Office of
Environment
& Heritage

RE: REVIEW OF ENVIRONMENTAL ASSESSMENT FOR NORTHBANK ENTERPRISE HUB (MP 10_0185), TOMAGO

ATTACHMENT A: OEH REVIEW – OUTSTANDING ISSUES

Figure 3-2 DEM and Layout of Proposed Development

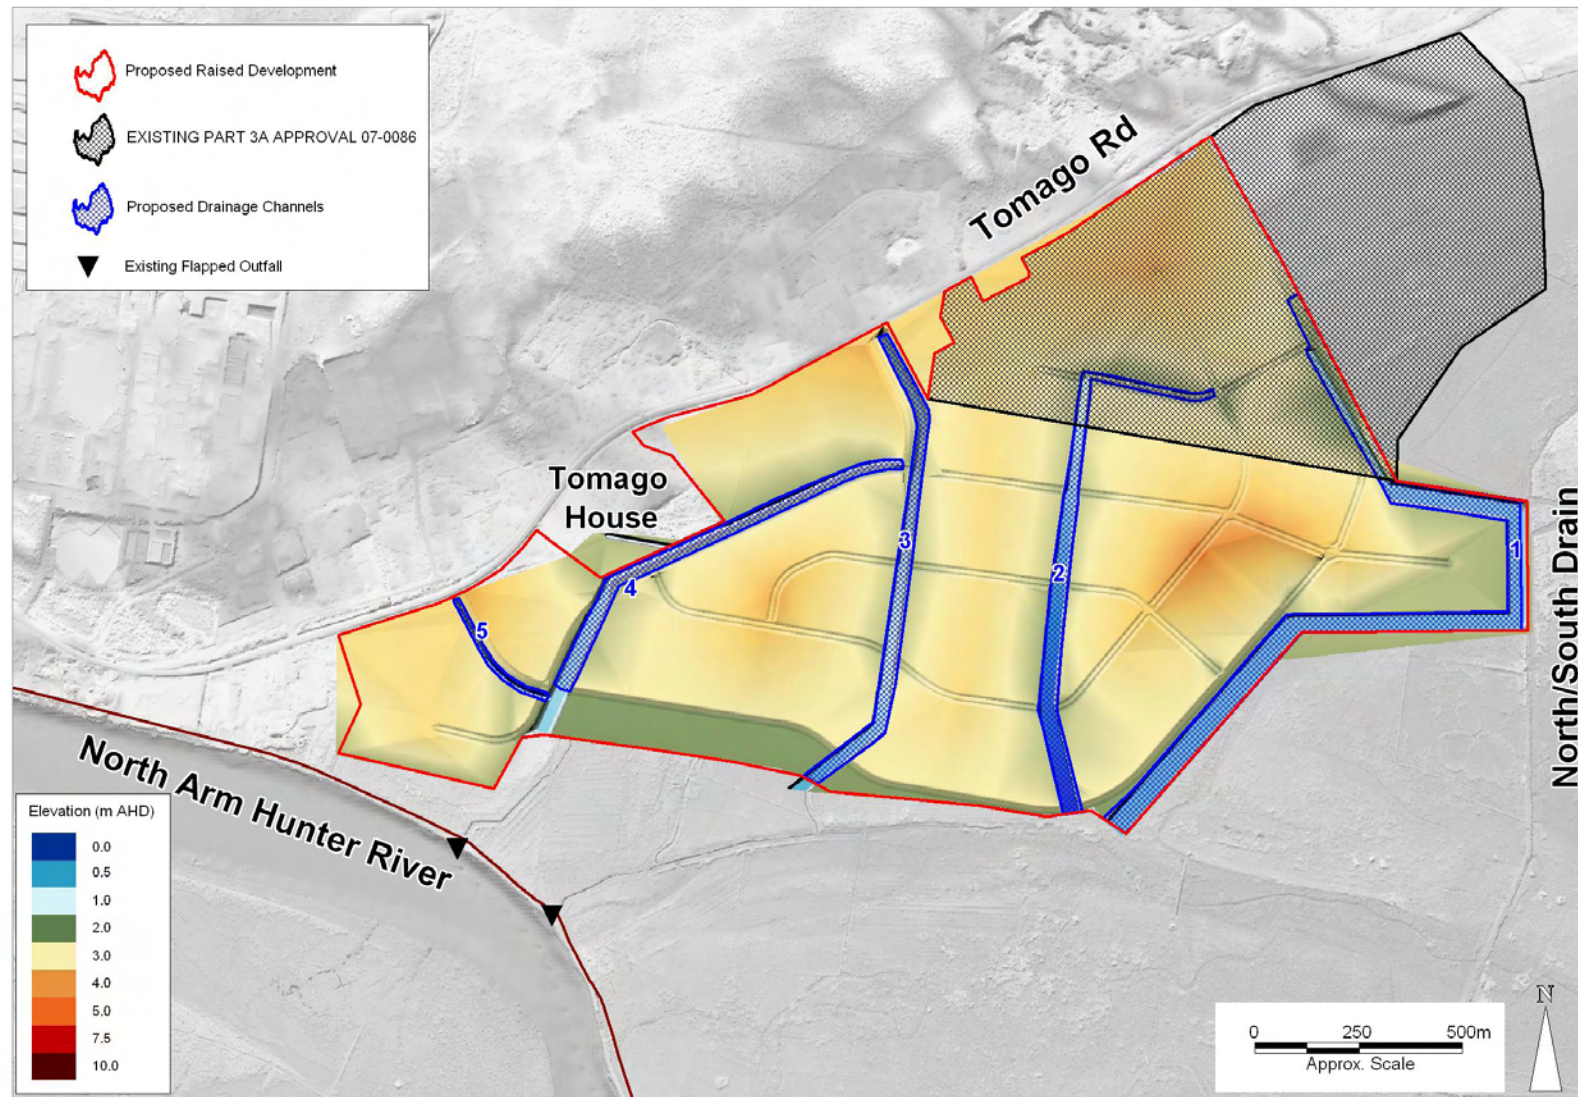
Section 6.4.1 states that "*the proposed fill footprint has been excluded from any nominated floodway area*". This comment seems to contradict Figure 3-2 of the Flood Study, which clearly indicates the floodway for the 1% Annual Exceedance Probability (AEP) design flood event with the outline of the proposed fill footprint. The location of the existing floodway as shown on Figure 3.2 can be compared to the information presented on Figure 2.5 and 2.8, which clearly indicate fill is proposed within the areas conveying the highest unit discharge on the left overbank of the Hunter River North arm.

Figure 7-2 Post Development Scenario (Partial Flood Bund) - 1 in 100 Year Flood Impact

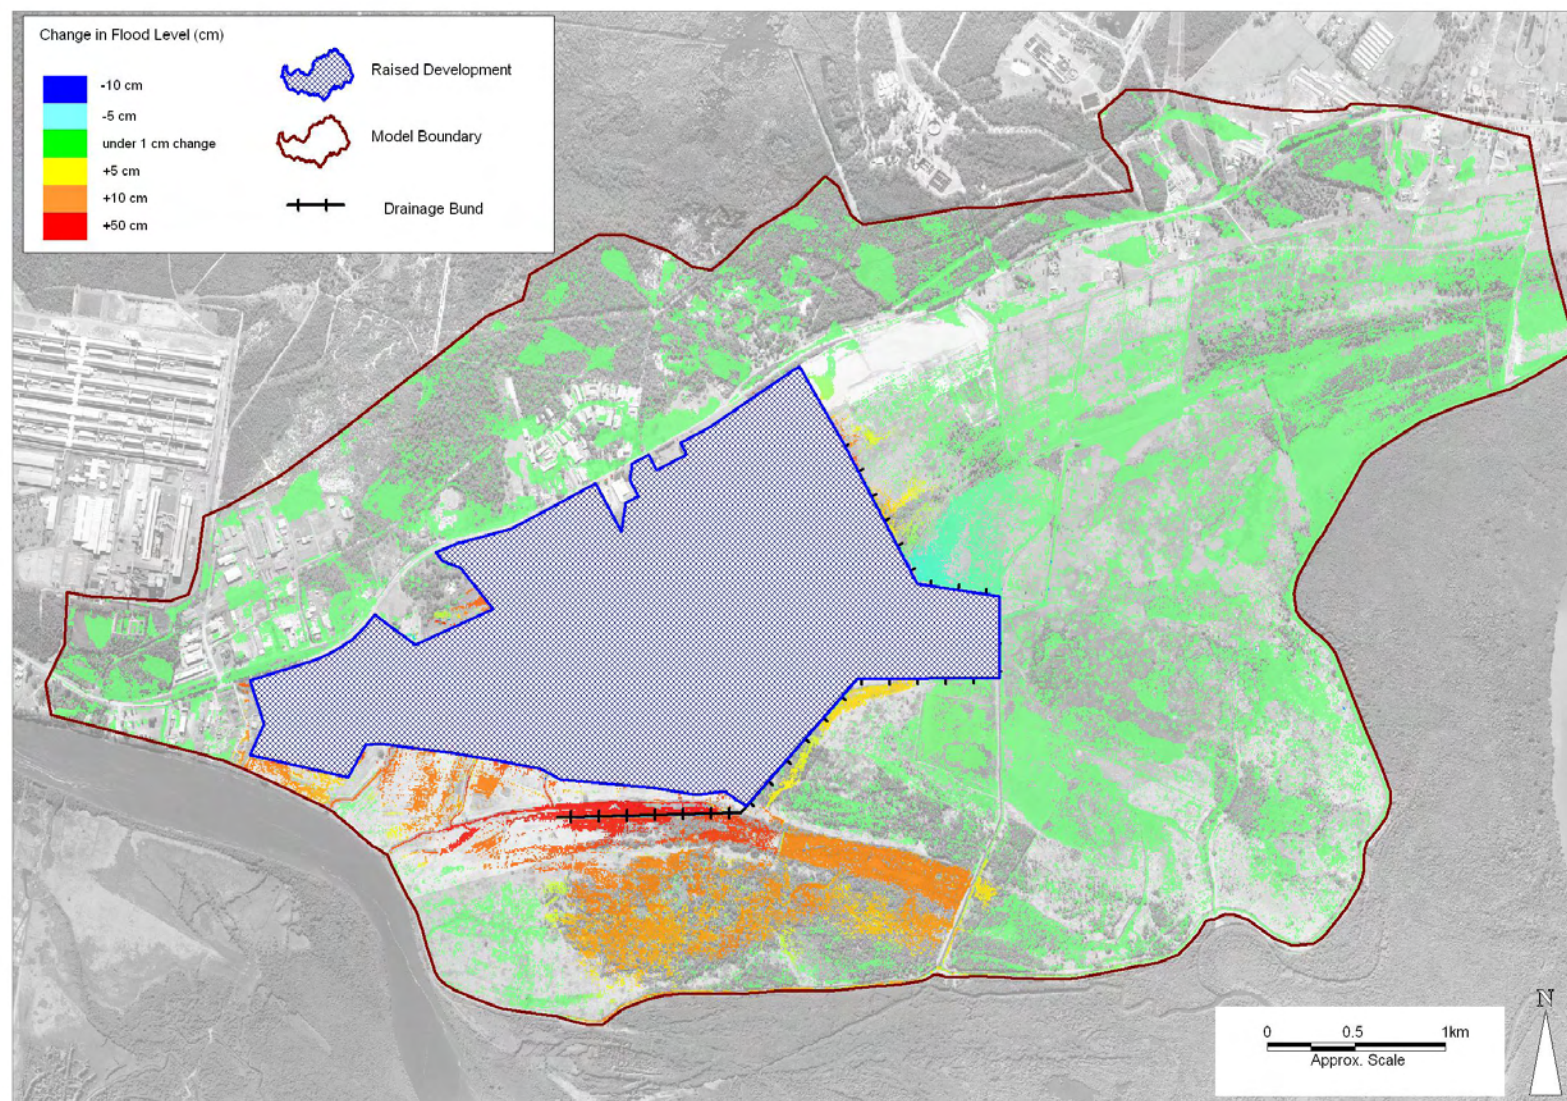
- Figure 7-2 indicates increases in flood levels external to the site – particularly to the east of the north-South drain. These impacts are on existing properties that are not owned by the applicant, and on an area that is primarily covered by wetlands and EEC. Therefore the increases should be as negligible as possible. The current impacts are unacceptable.

Title:
Developed Sub-catchments

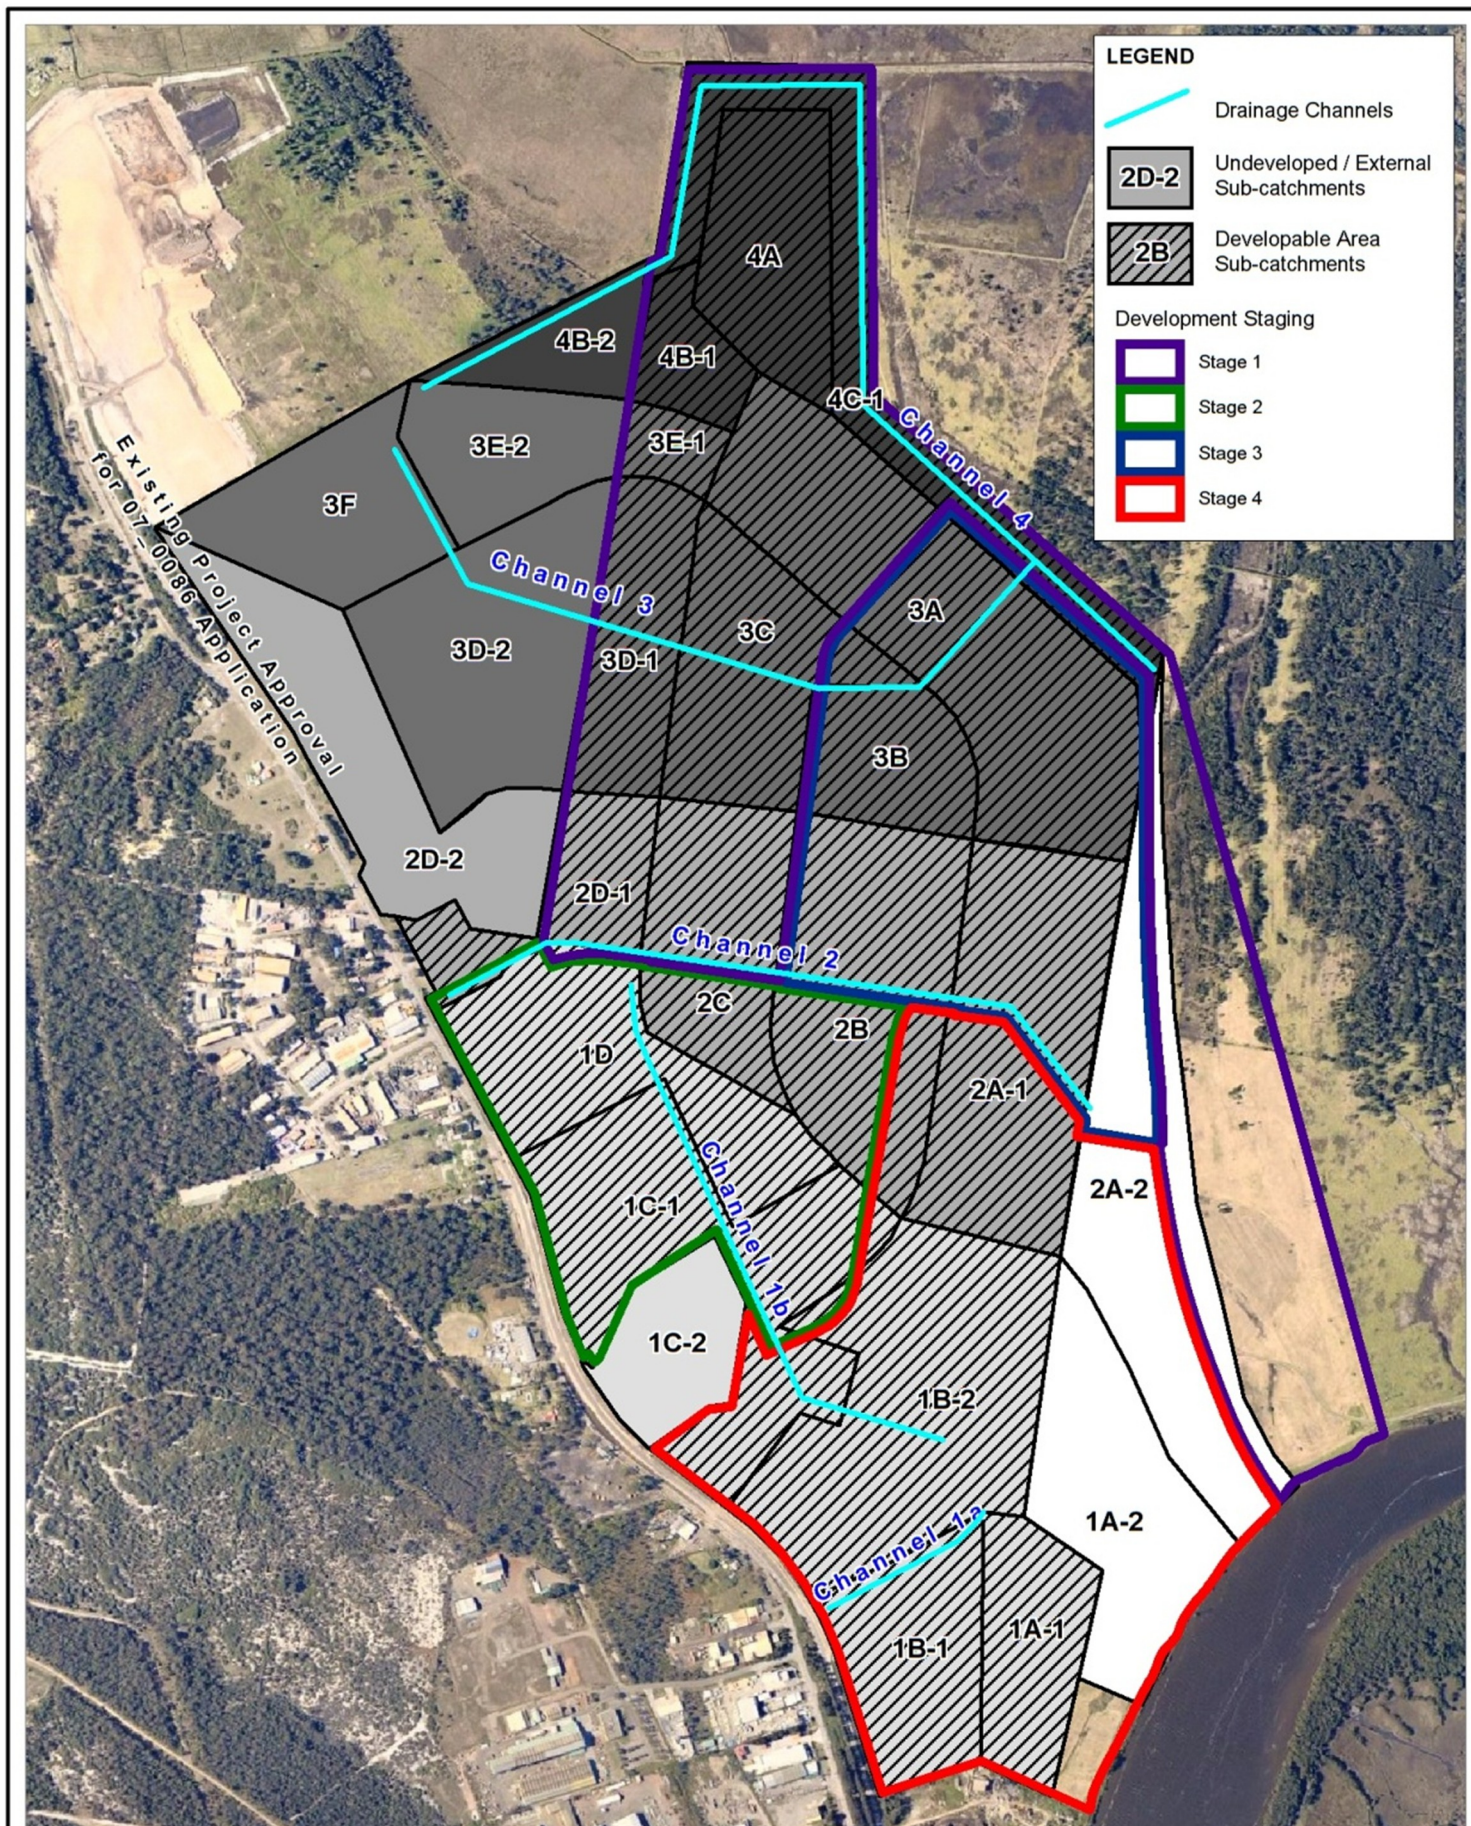
It is unclear where channels 1a and 1b connect in to, prior to discharging from the site.

The location of the bio-retention swales shown on Figure 6-6 do not correspond with the location of the drainage channels shown on Figure 6-1.

Figure 6-4 Typical Section – Channel 4 (BMT WBM, 2012a)

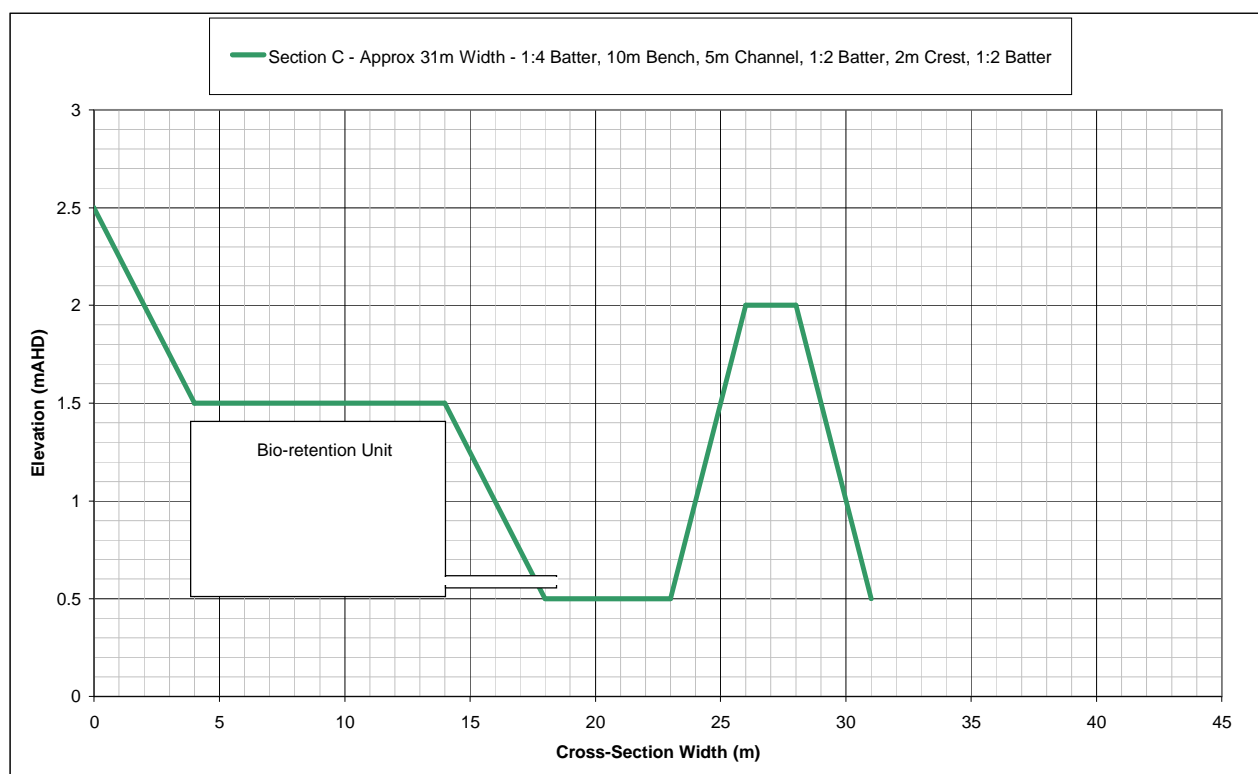
- c) The biofiltration designs shown in Figures 6-3 and 6-4 need revision. It is unclear what a 'bio-retention unit' actually is, and there is no way that any form of 'bio-retention' can be elevated above the invert of a channel which it discharges to – it is anticipated that the hydraulics from such a system would not work and the 'bio-retention unit' would be saturated so long as the channel immediately adjacent to it

has water in it. It must also be noted that it is anticipated that this development could have tidal impacts, which have not been taken into account with the stormwater drainage design. The 'typical bio-retention swale configuration' as shown in Figure 6.5 cannot work as shown on Figures 6.3 and 6.4
